Subject: Revised Request for Modification of the Phased Section 404 Individual Permit and Section 401 Individual Water Quality Certification for the construction of the Triangle Expressway Southeast Extension from NC-55 Bypass in Apex to I-40, Wake and Johnston Counties. TIP Nos. R-2721, R-2828, and R-2829. Federal Aid Project No. 0540047.

We are requesting a modification to the Section 404 Authorization (SAW-2019-02240) and the associated 401 Water Quality Certification (Permit No. 20181249). This request is necessary due

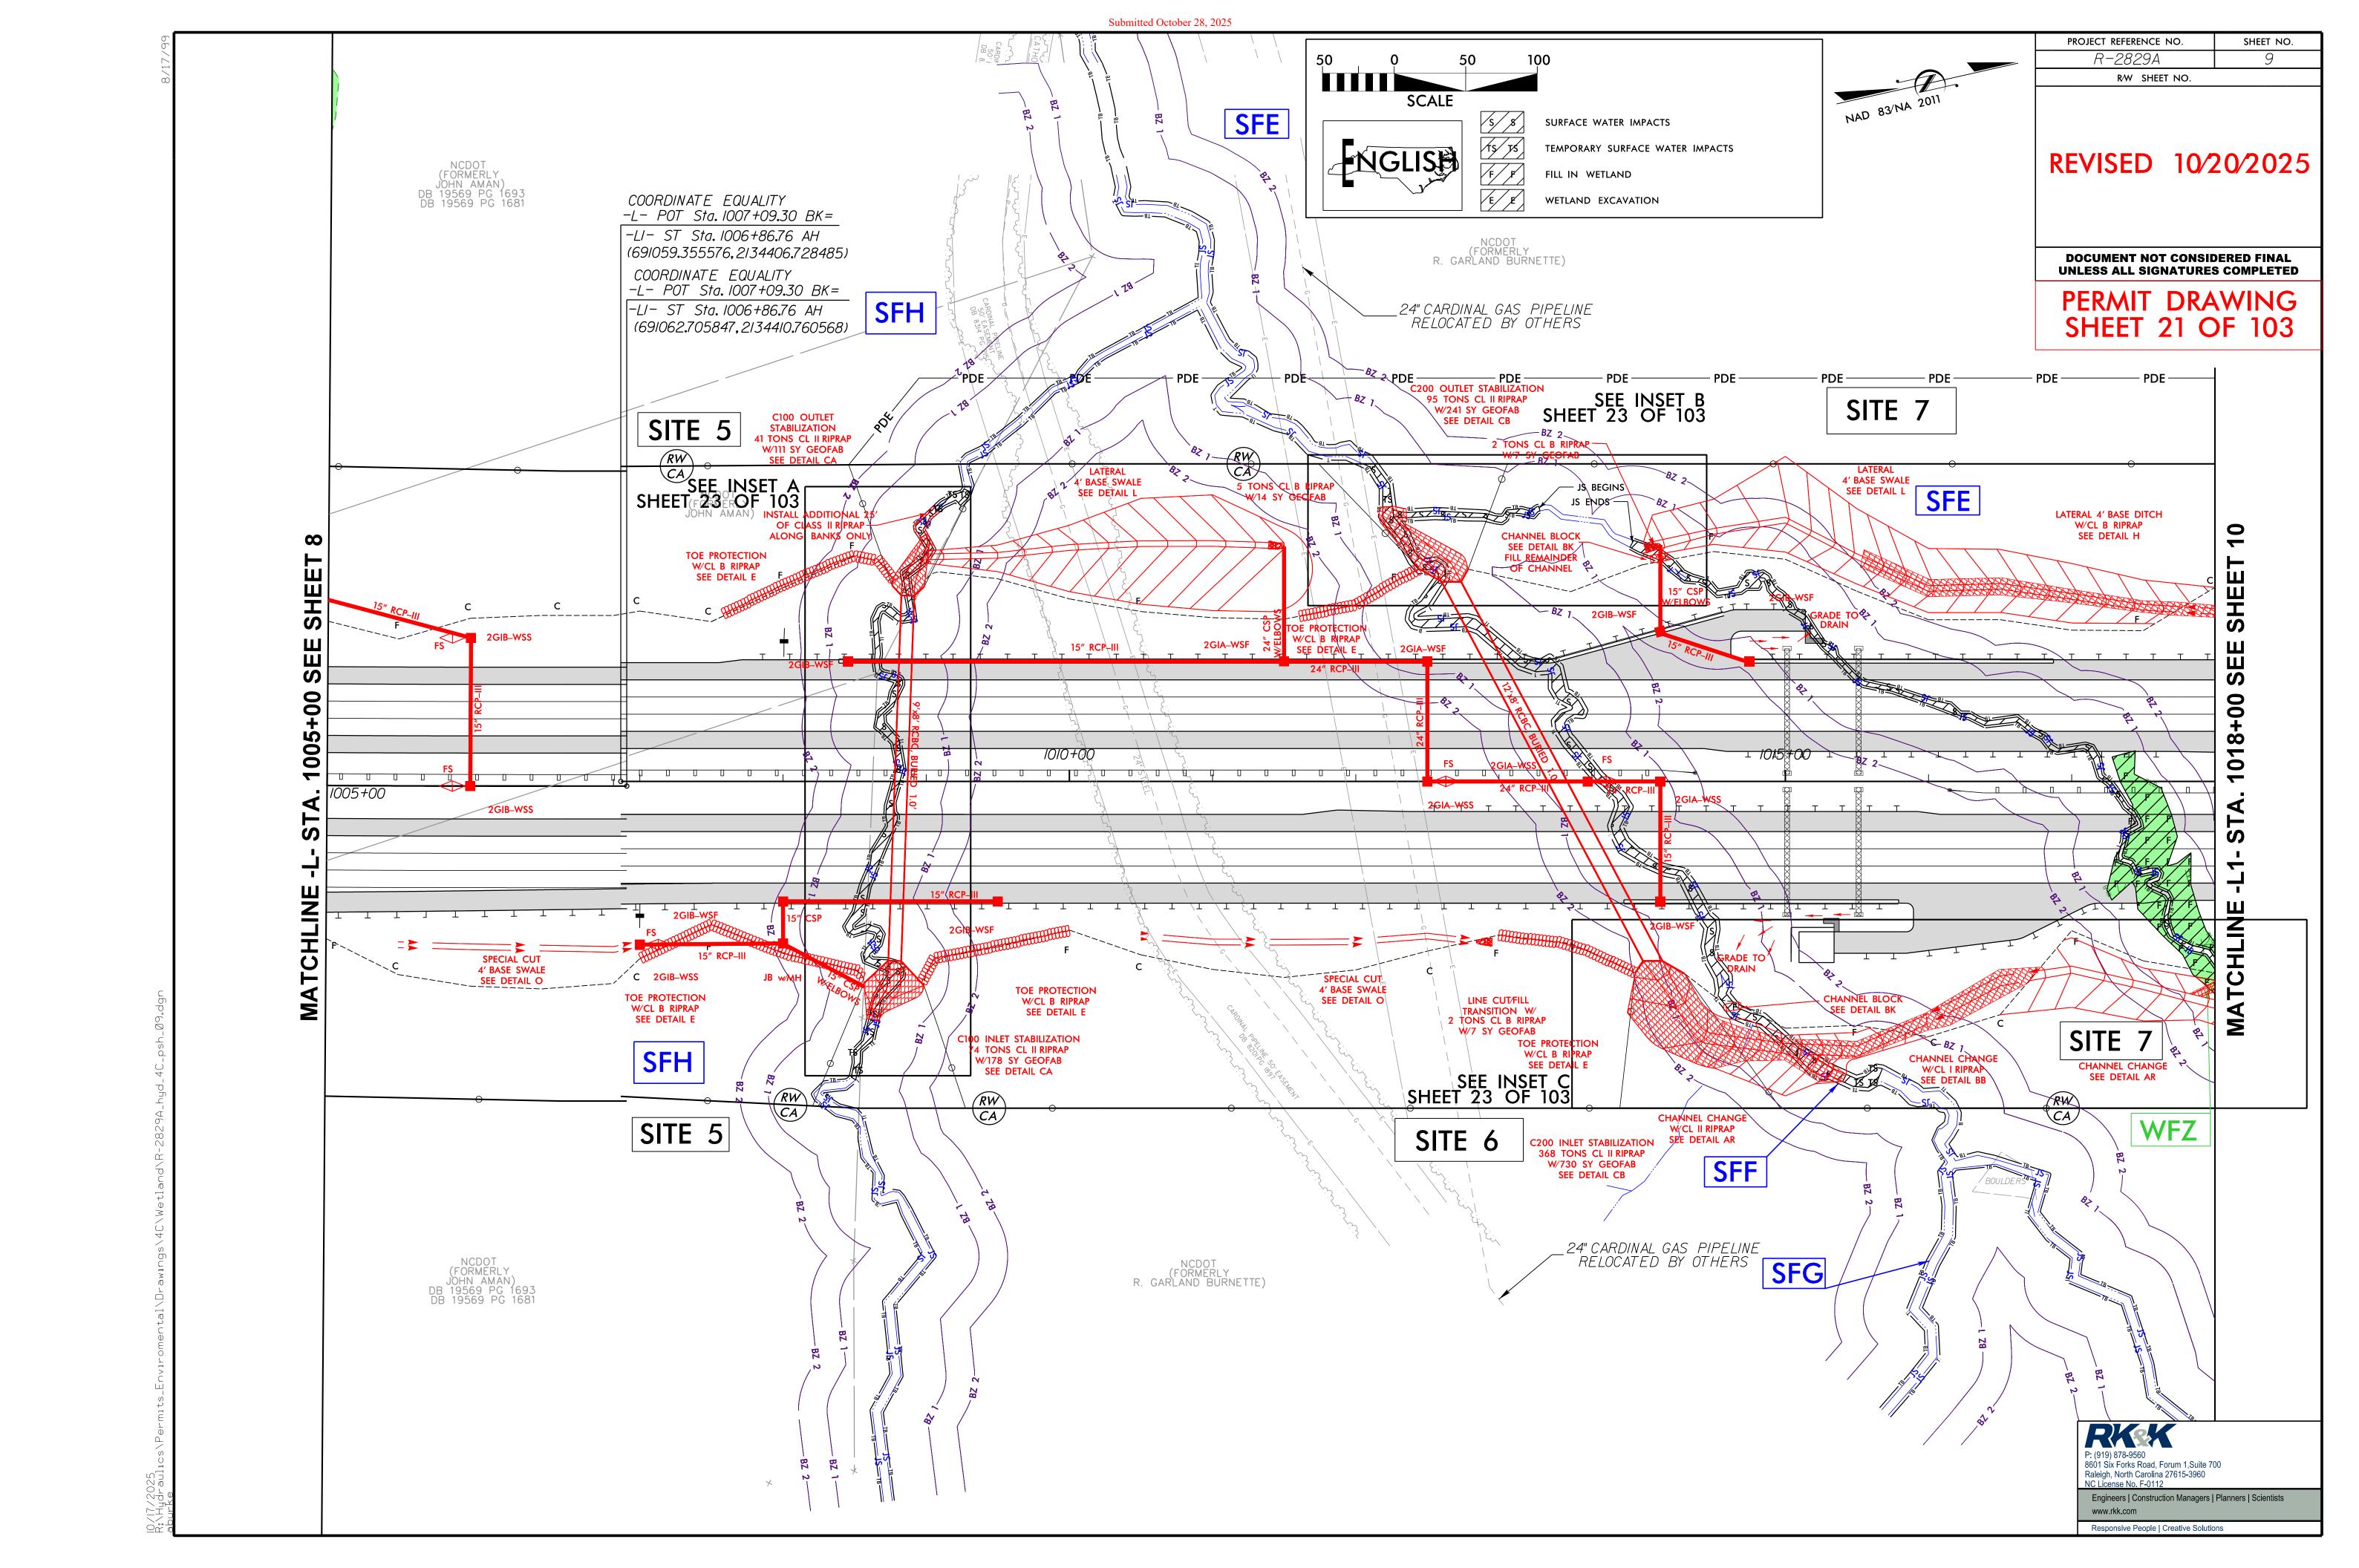
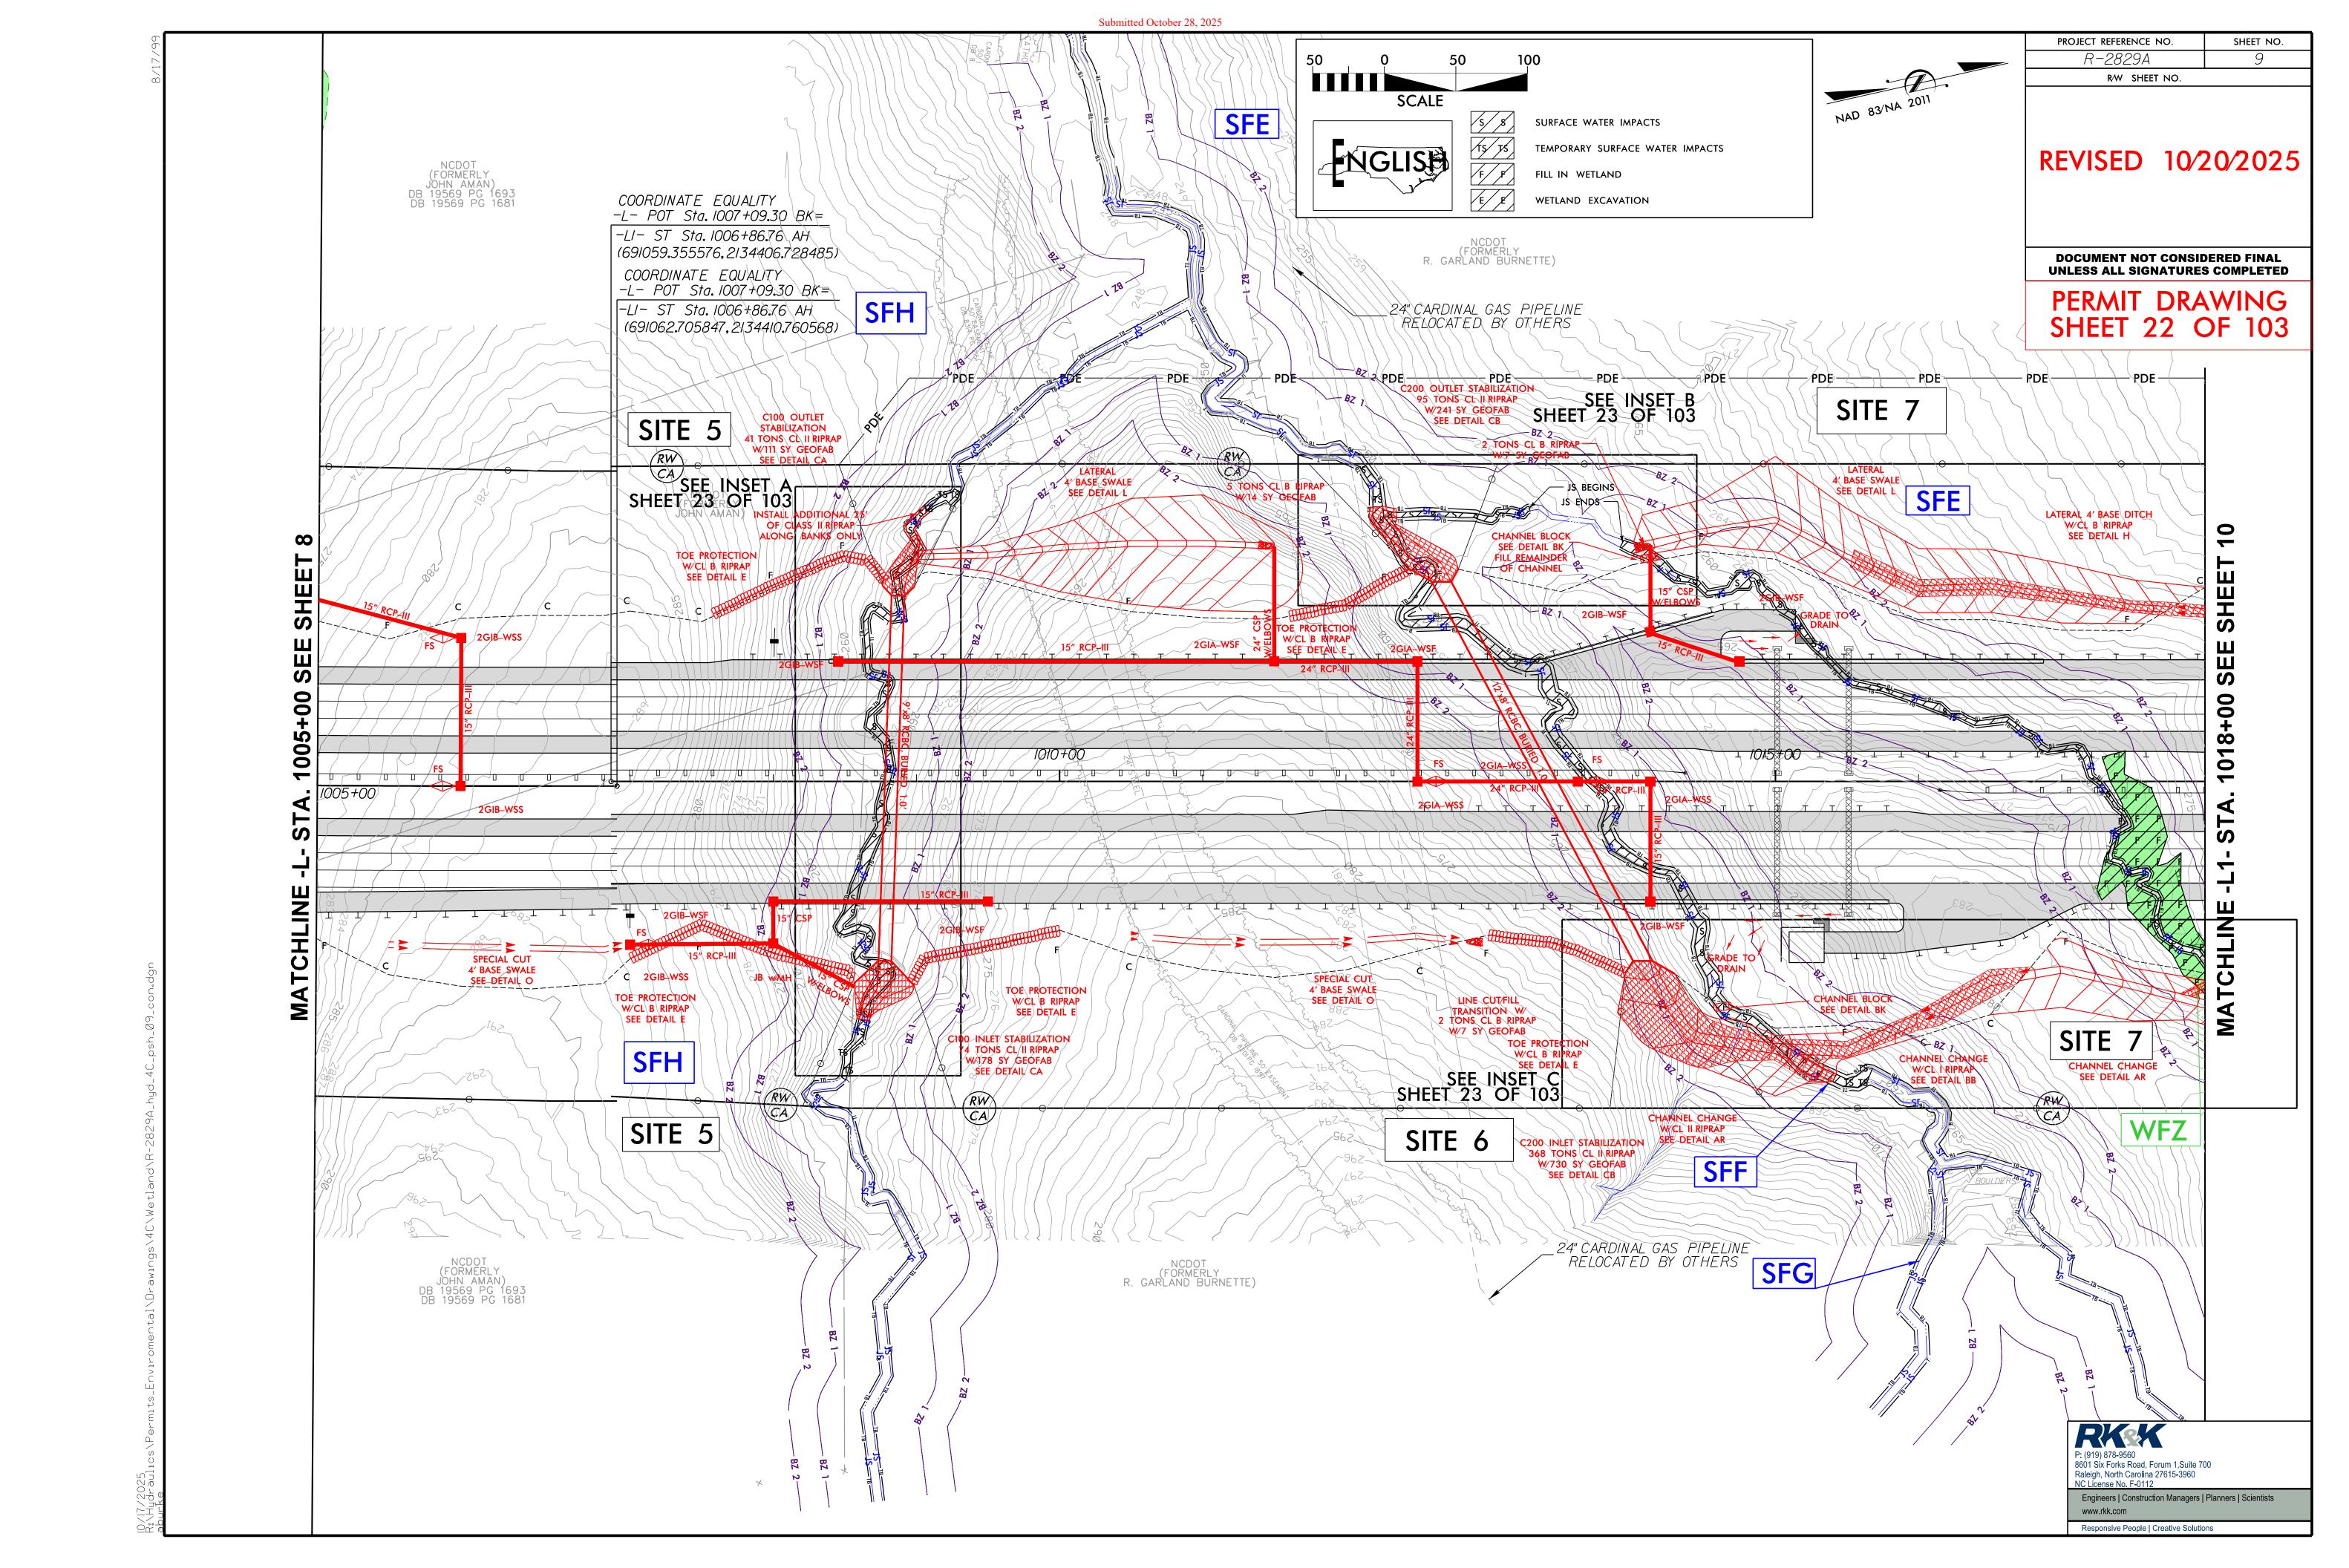
Roadway Site 3

Stream SEY comes onto the project and stops at the Bushy Branch wetlands and bridge end bent on -L- RT. This stream is a low, flat area and is undefined as it travels into the wetlands. Per recent field reviews, it was determined that additional toe protection rock shall be installed along the new bridge end bent toe of slope for stabilization of this low-lying area. This rock installation required the mechanized clearing limits surrounding the toe of slope to be revised to permanent fill in wetland impacts.

Roadway Site 3 wetland impacts

- Permanent wetland fill: 0.284 ac (previously 0.257 ac, increase of 0.027 ac)
- Mechanized clearing in wetlands: 0.071 ac (previously 0.098 ac, decrease of 0.027 acre)
